From: Contact Centre (CRM) <contact@ribblevalley.gov.uk>
Sent: 12 March 2024 19:40
To: Planning
Subject: Planning Application Comments - Application 3/2023/1034 FS-Case-594952895

Planning Application Reference No.: Application 3/2023/1034

Address of Development: 23 Abbey Farm View Whalley Clitheroe BB7 9YF

Drawing title:
DAIKIN ALTHERMA 3
High Capacity Monobloc
(9-11-14-16 class)

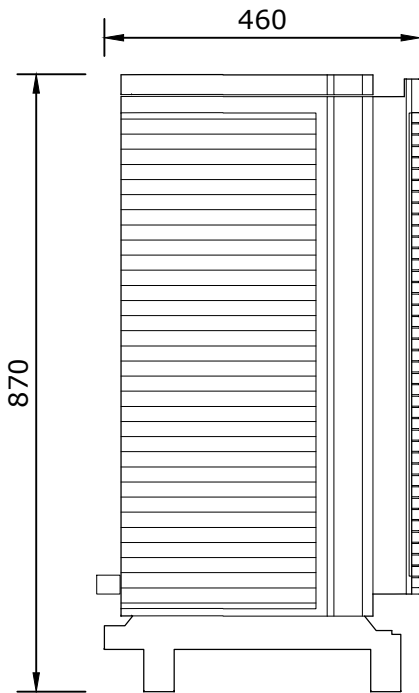
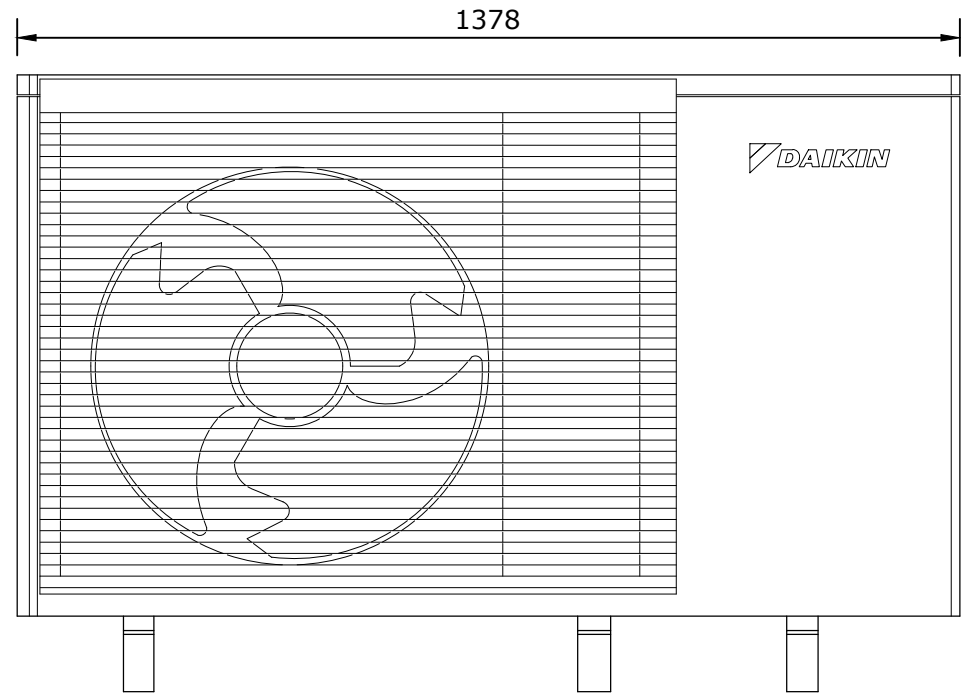
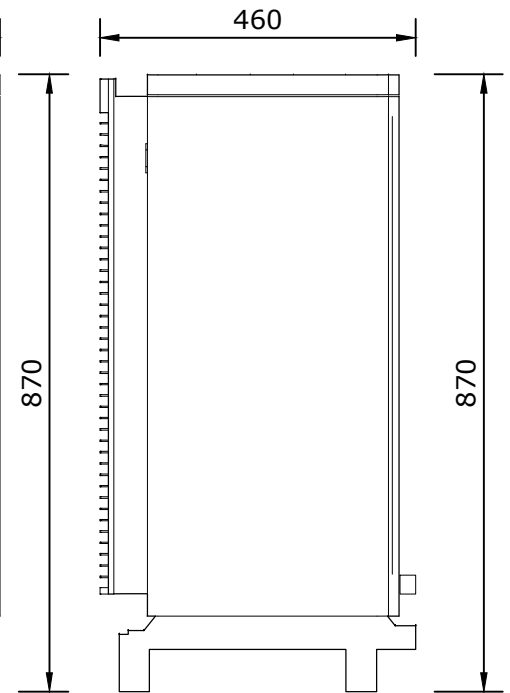
Comments: The proposed air source heat pump has a noise level of 65dB. This is unacceptable due to the [REDACTED]. This would severely hinder [REDACTED]. The puzzling thing is there are plenty of other models with half the noise pollution. I would not oppose one of these. Due the above I strongly oppose this application.

Comments: The proposed air source heat pump has an unacceptable noise level of 65DB. The location is very close [REDACTED] which would hinder [REDACTED]. There are other heat pumps available with half the noise pollution. Why can't these be used? I strongly contest this application but would have no issue with another model with a more acceptable noise label.
